From: Clerk [REDACTED]
Sent: 05 March 2020 09:53
To: Planning.Responses <Planning.Responses@arun.gov.uk>
Subject: RE: Please find attached amendment on planning application Ref: WA/48/19/RES

At a meeting of the Barnham and Eastergate Parish Council's Planning & Environment Committee the Committee resolved to reconfirm their previous objection as below and add some additional objection points:

APPLICATION NO: WA/48/19/RES

Site Address: Land to the East of Fontwell Avenue Fontwell Avenue Fontwell

Drawing Title
Planning Layout

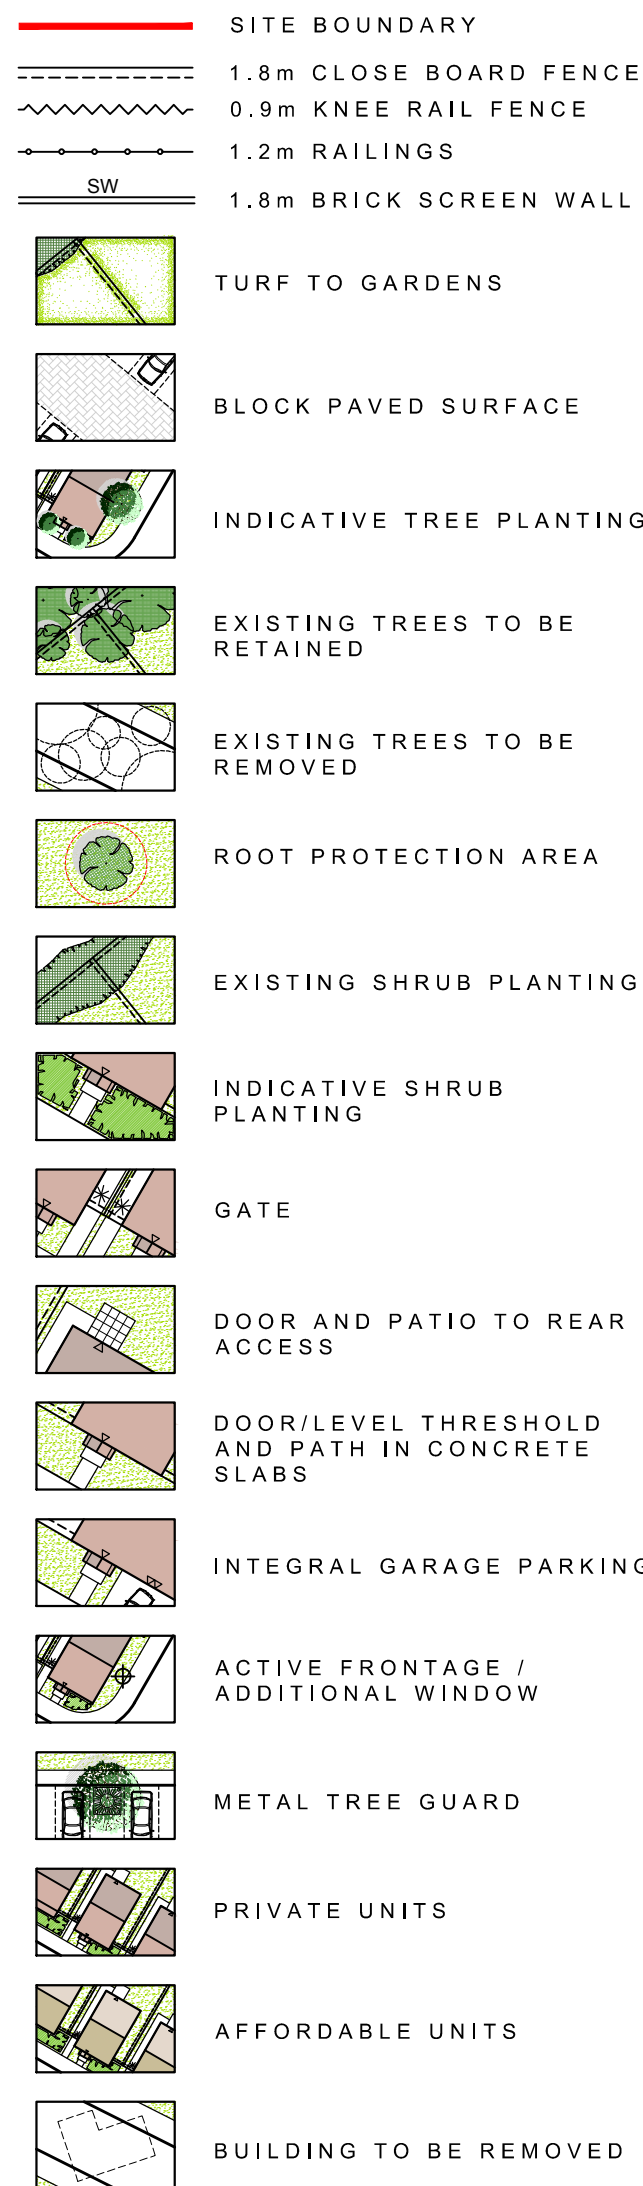
The major issue for the Parish Council is that it would appear that the revised layout Plan for the development showed the removal of the ancient hedgerow which the Committee maintain must be retained in its current location (see previous objection). The Committee wish to see Condition 10 of WA/22/15 strengthened to ensure that the details of the hard and soft landscaping and details of existing trees and hedgerows to be retained specifically includes a statement that says the current ancient hedgerow that forms part of the Parish boundary must be retained in its current position and not uprooted as the danger of doing that is the hedge will not survive.

The Committee also instructed the Clerk to write to the Secretary of State to inform him that the developer's latest plans potentially show that the hedges will not be retained in their current location and to ask him to exert some pressure on ensuring this they must not be removed or relocated, but rather incorporated into the layout design. The Clerk was also asked to write to the Woodland Trust and CPRE to obtain support for this stance. Policy ES10 of the Barnham and Eastergate Neighbourhood Plan refers.
